# KITTITAS COUNTY

### MEMORANDUM

DATE: December 5, 2014

SUBJECT: Sullivan Short Plat SP-14-00003

DATE: 08/2014  
 JOB NO.: 14085  
 SHEET 1 OF 2

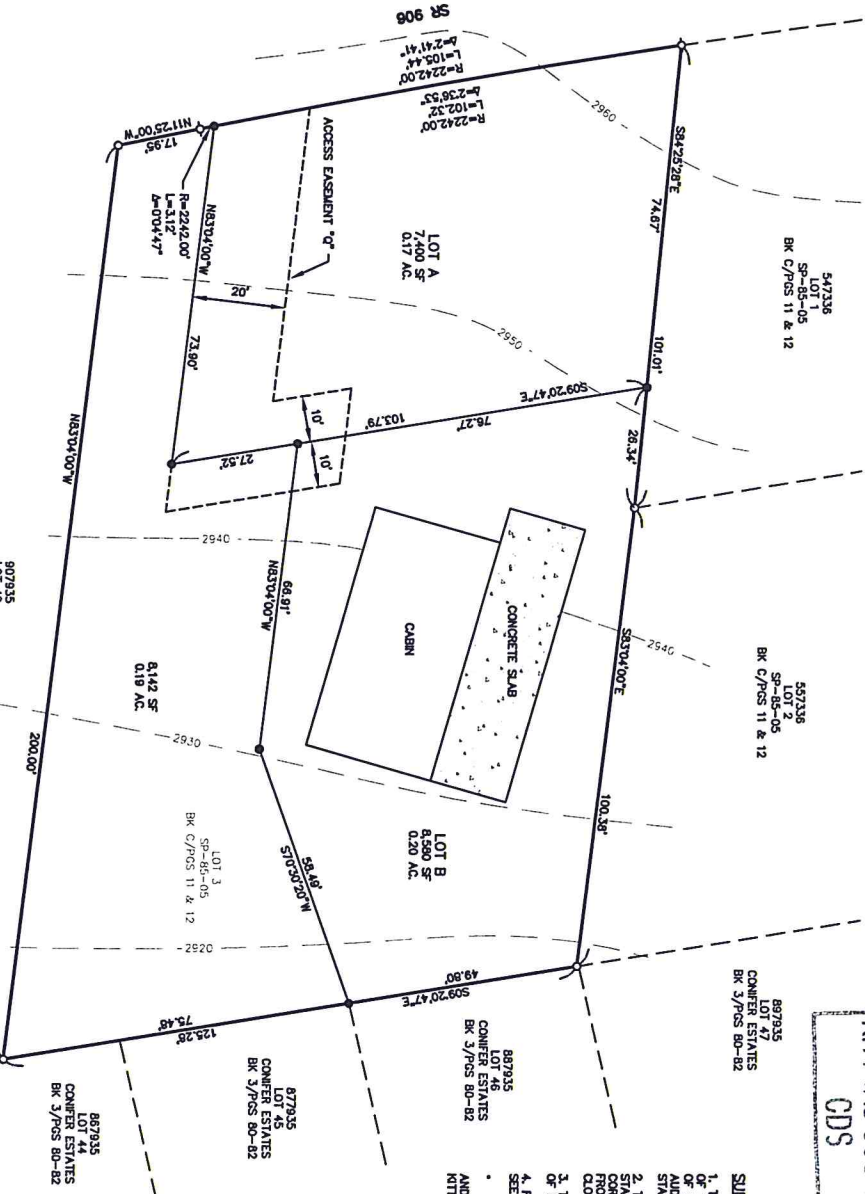
1. Access: Access to this property is from SR 906. Comments from WSDOT require the applicant to contact Mark Kaiser to update the existing access permit. The access permit must be approved prior to final approval of the short plat.

2. Access Easement: Current road standards require a minimum 20' width driveway easement. A minimum of 30' is recommended in order to provide snow storage during the winter season.

3. Joint-Use Driveway: A joint-use access shall serve no more than two tax parcels. See Kittitas County Road Standards, 9/6/05 edition.
  - a. Access easements shall be a minimum of 20' wide. The roadway width shall have a minimum width of 12'.

- b. The surface requirement is for a minimum gravel surface depth of 6".
  - c. Maintenance of driveway approaches shall be the responsibility of the owner whose property they serve. The County will not maintain accesses.
